An Bord Pleanála Oral Hearing

Case reference: PL06F.301908

Submission by

Sabrina Joyce-Kemper

PROJECT: Greater Dublin Drainage Scheme Ground Investigation

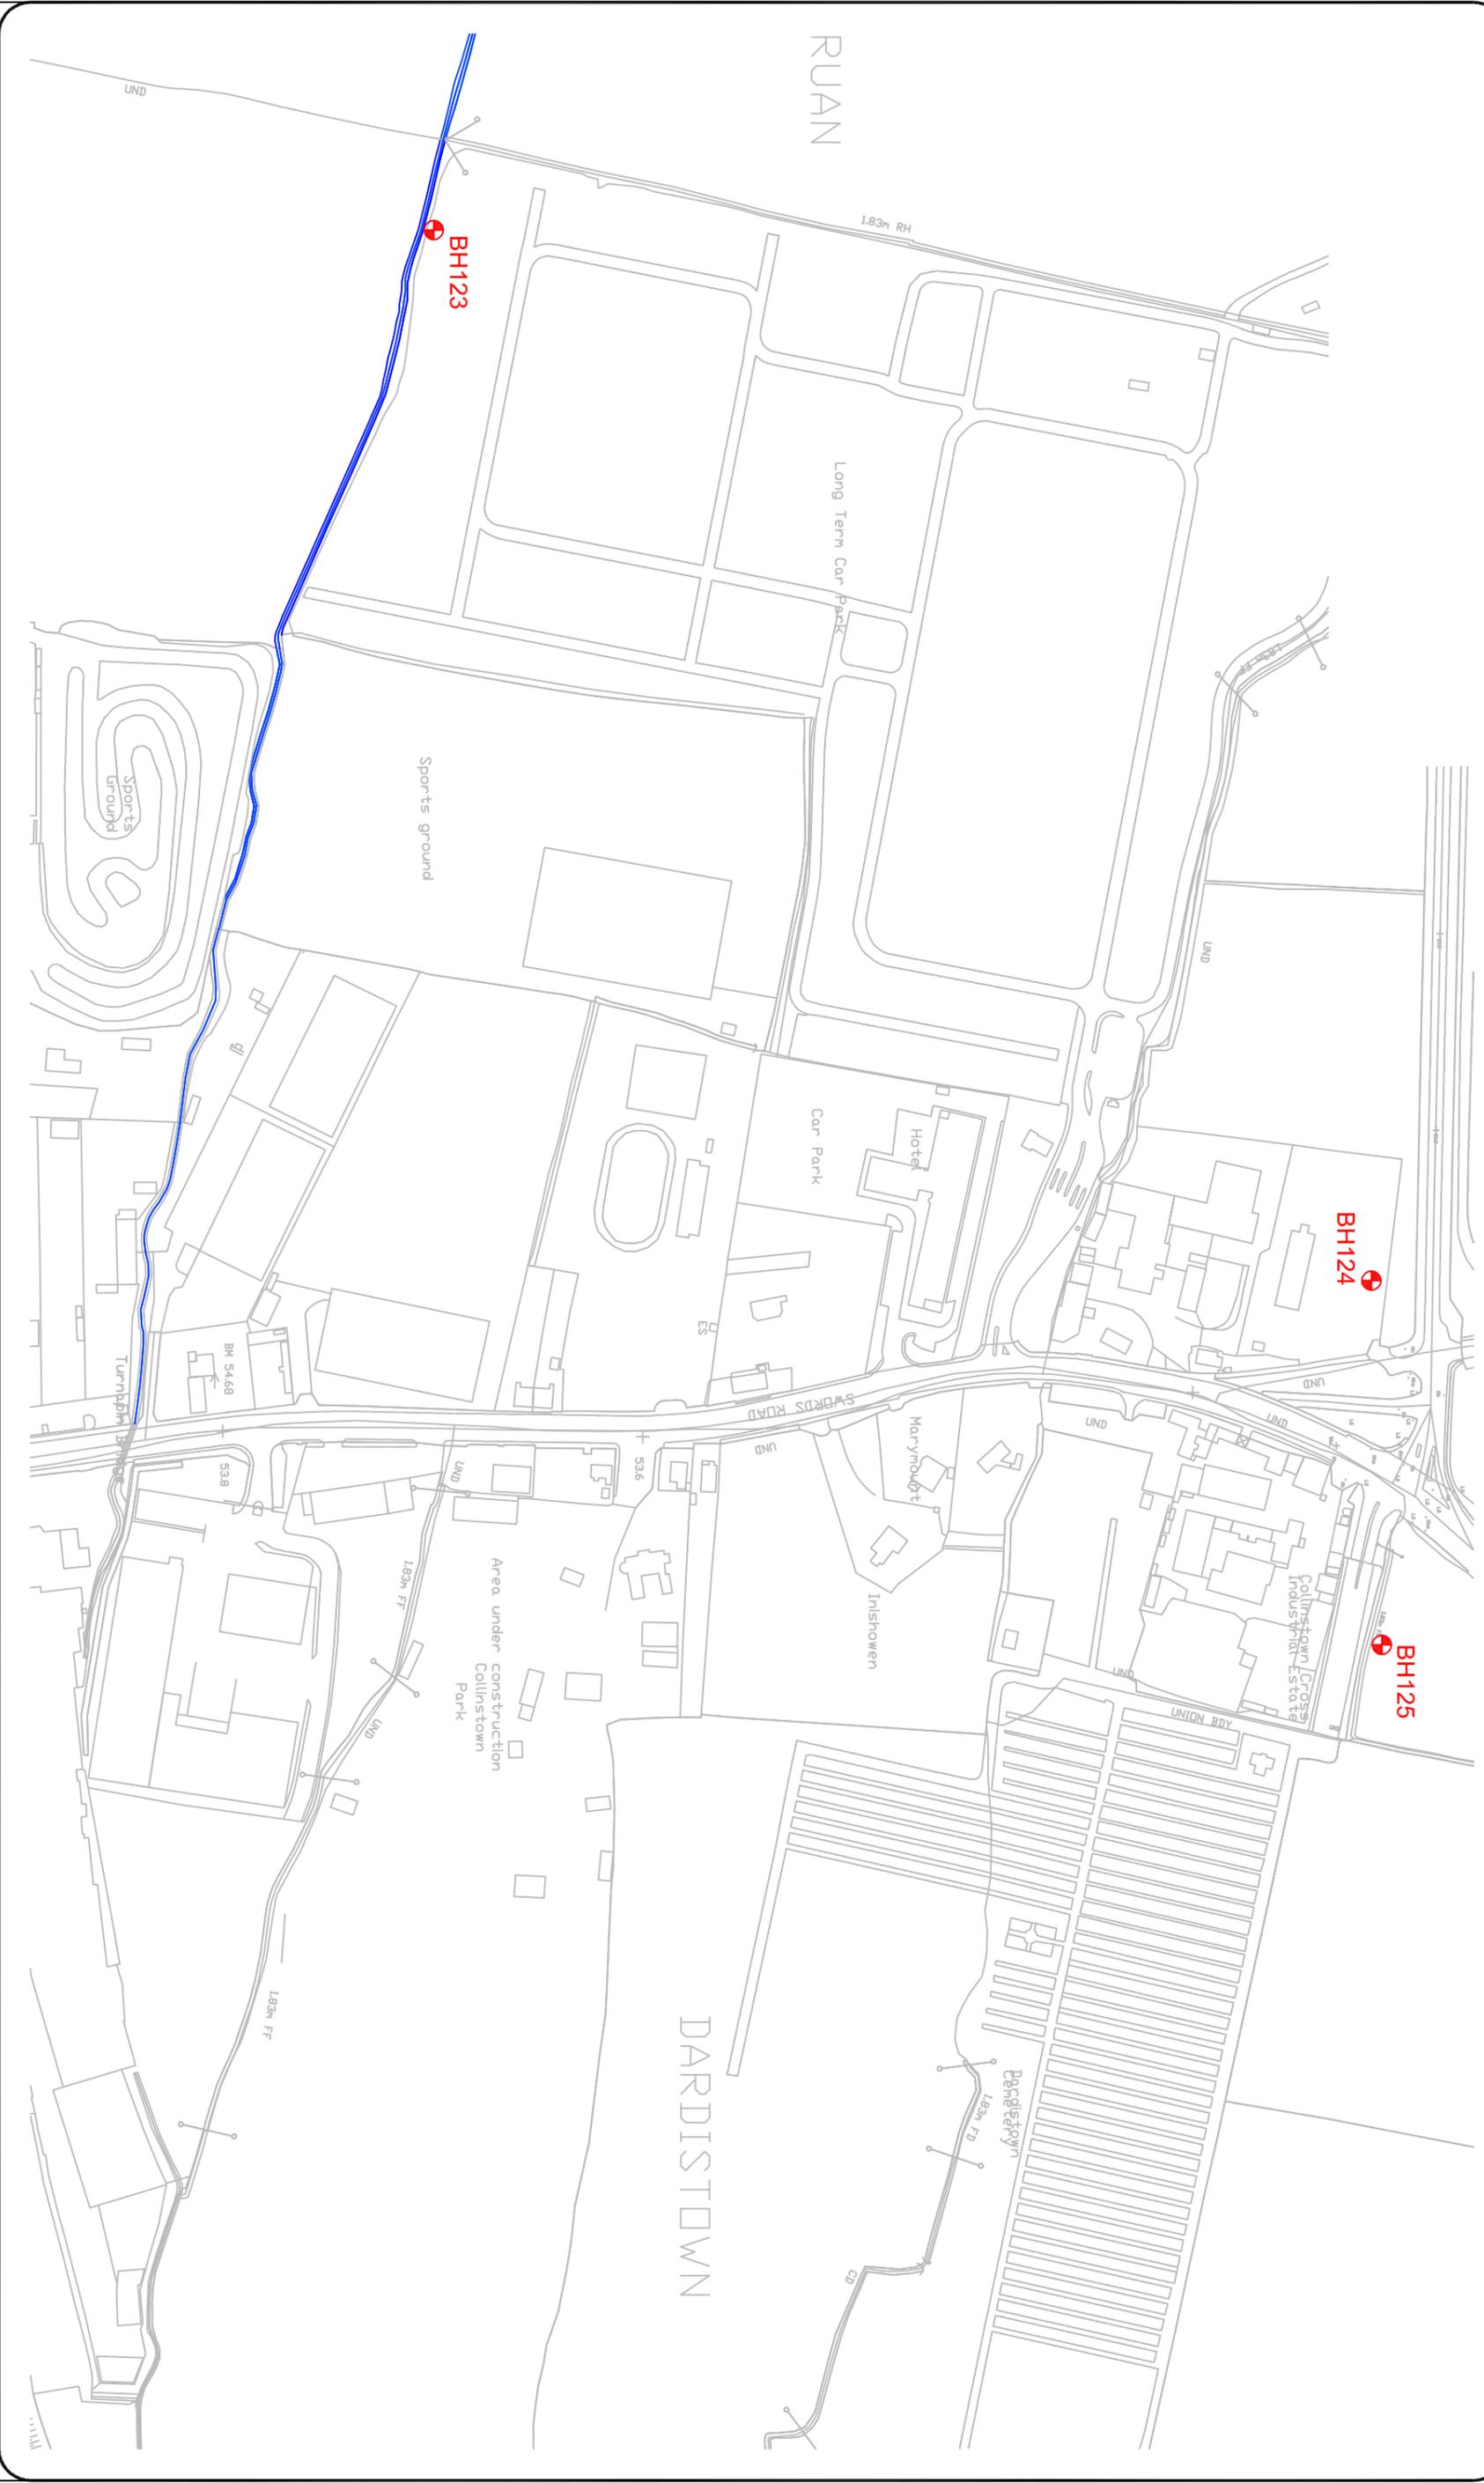
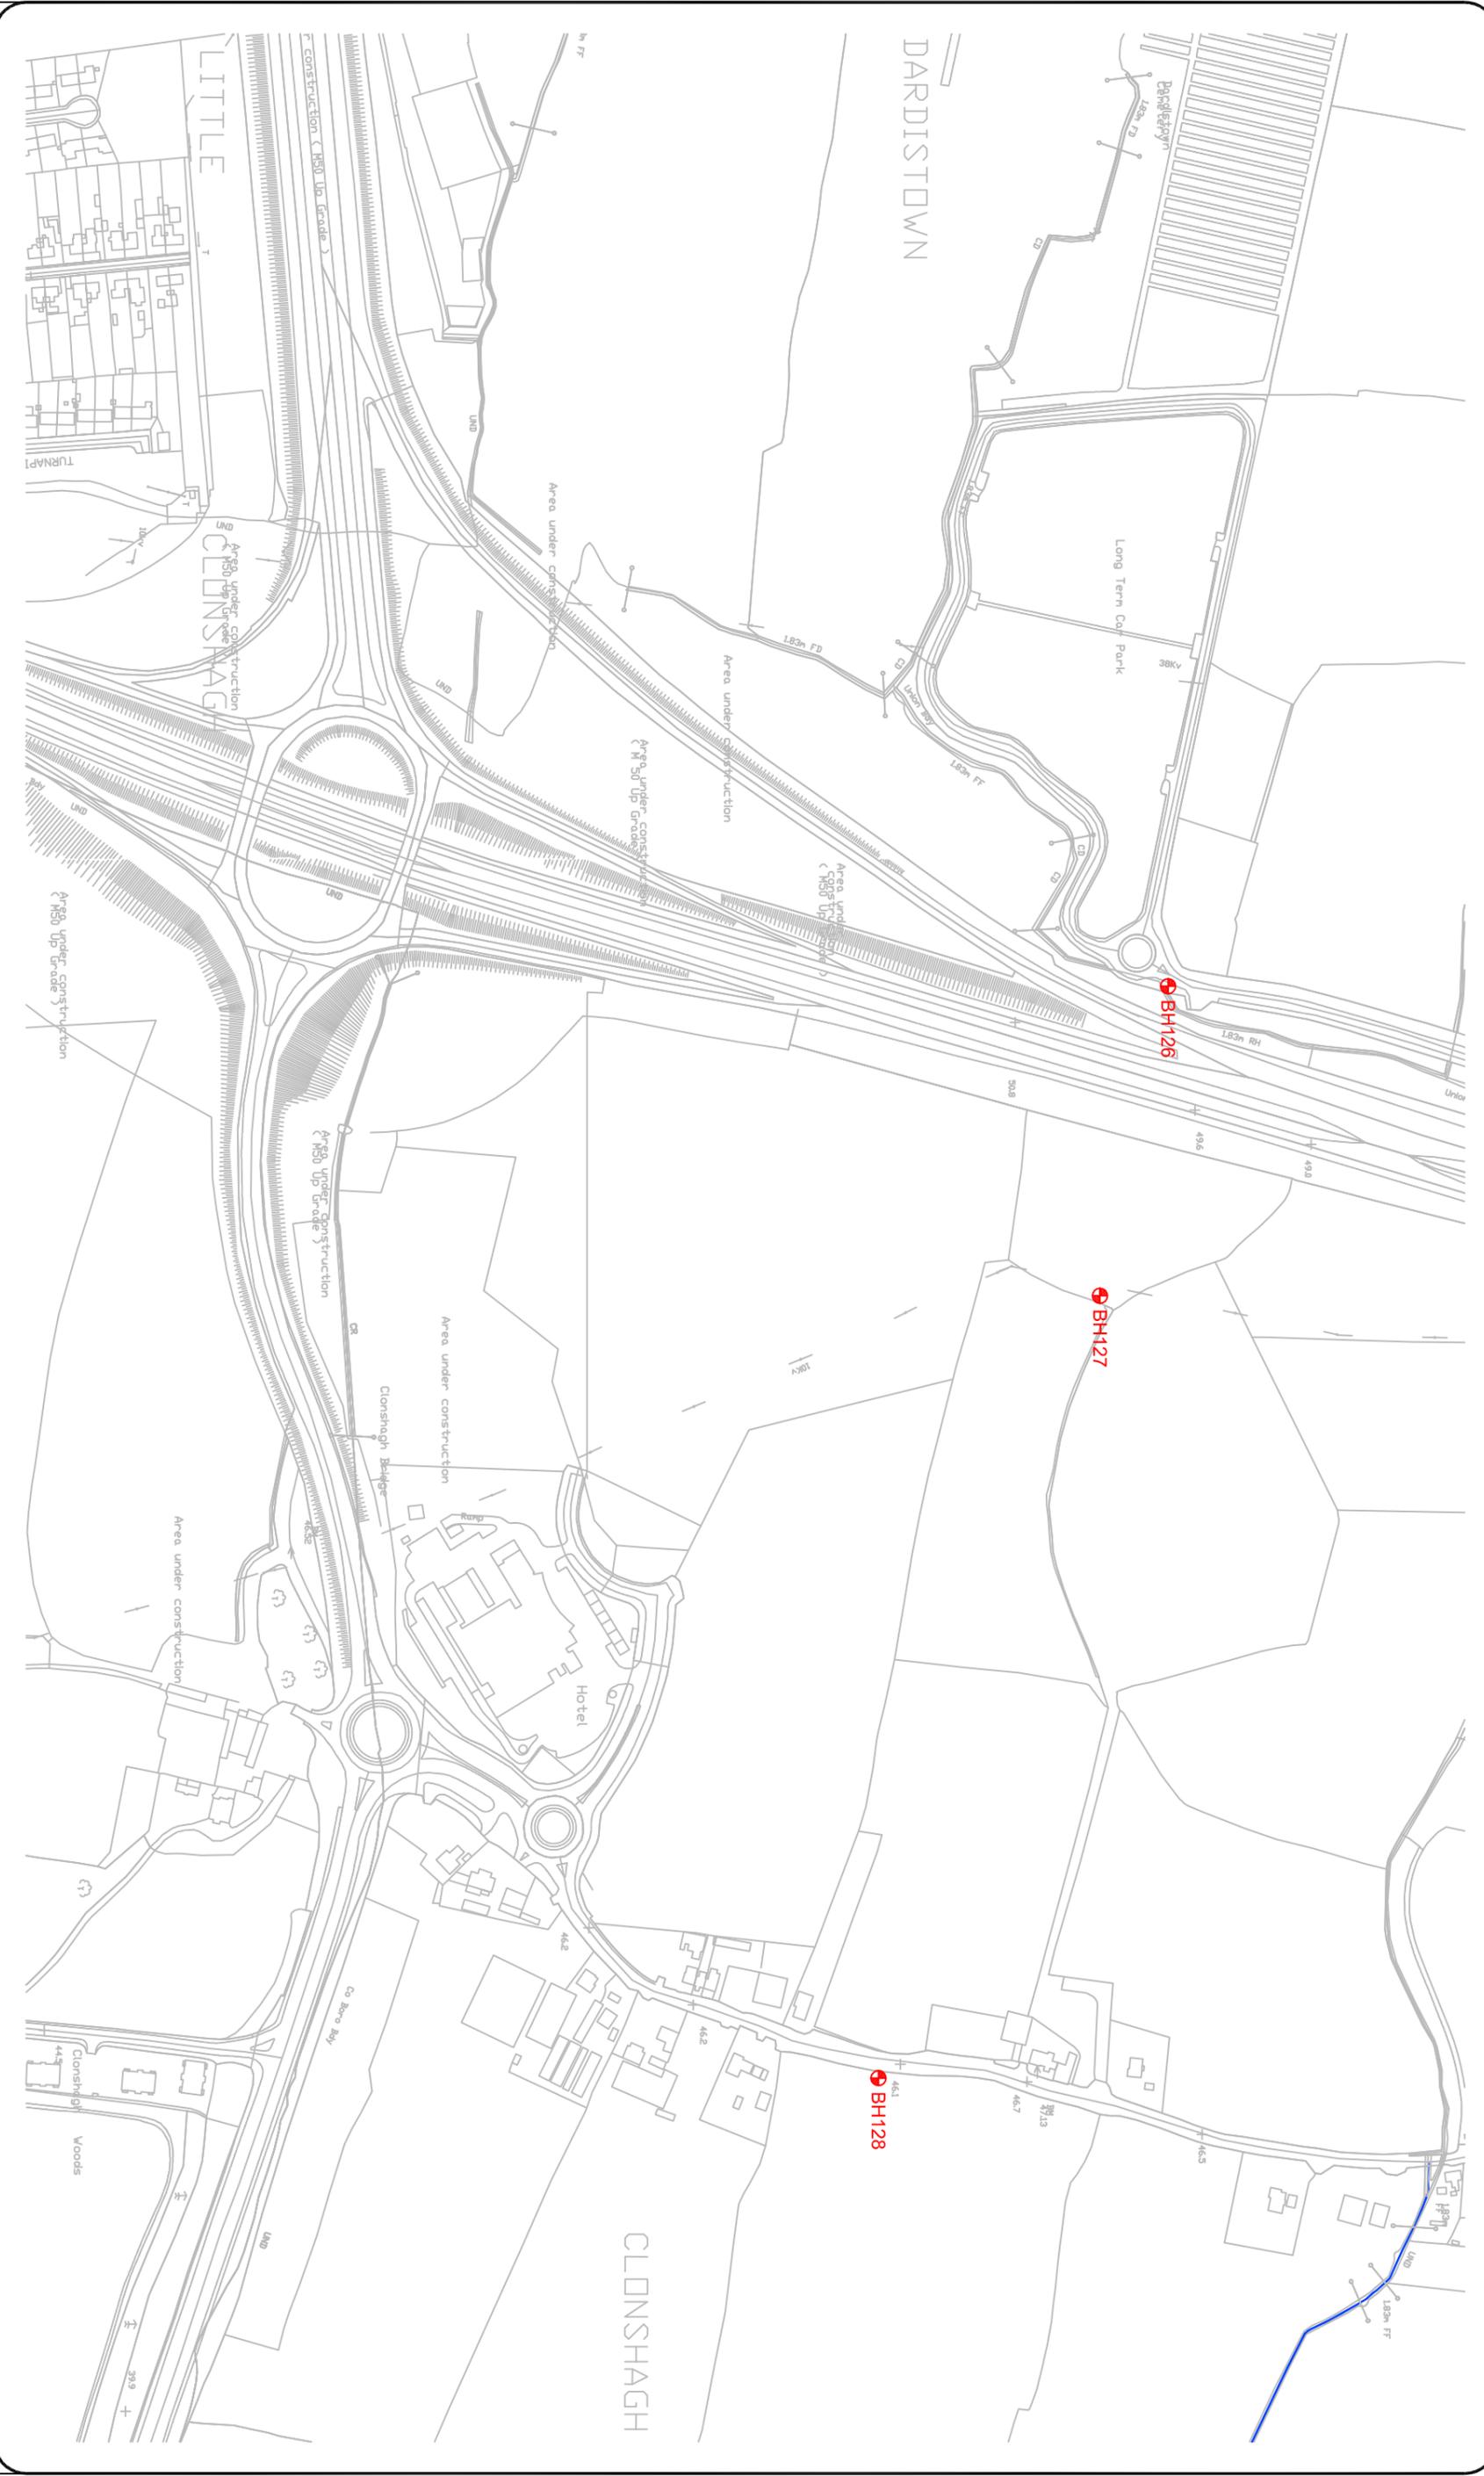
26. Irish water does not have actual scientific information regarding the geology directly under Baldoyle Estuary where the Tunnel boring will actually take place. Borehole samples were taken each side of the estuary on dry land but none were taken within the estuary itself due to its strict protected status. The NIS states the following: *"The risk of a surface breakout by bentonite drilling fluid cannot be negated completely due to variability in the underlying geology. A detailed geophysical survey has been carried out along the proposed route in order to anticipate the risk of weak formations and possible faults that may increase the risk of a bentonite breakout. However, should the TBM encounter voids within the formation (such as a fissure or weathered area of rock), and then material can be forced to the surface under pressure to create a breakout. In the littoral and sub-littoral environments, the presence of bentonite at the surface can have a notable impact on sediment turbidity and suspended load. This increase in turbidity could result in increased siltation and the smothering of sediments and organisms accompanied by a reduction in the light available to the seabed for photosynthesis."*
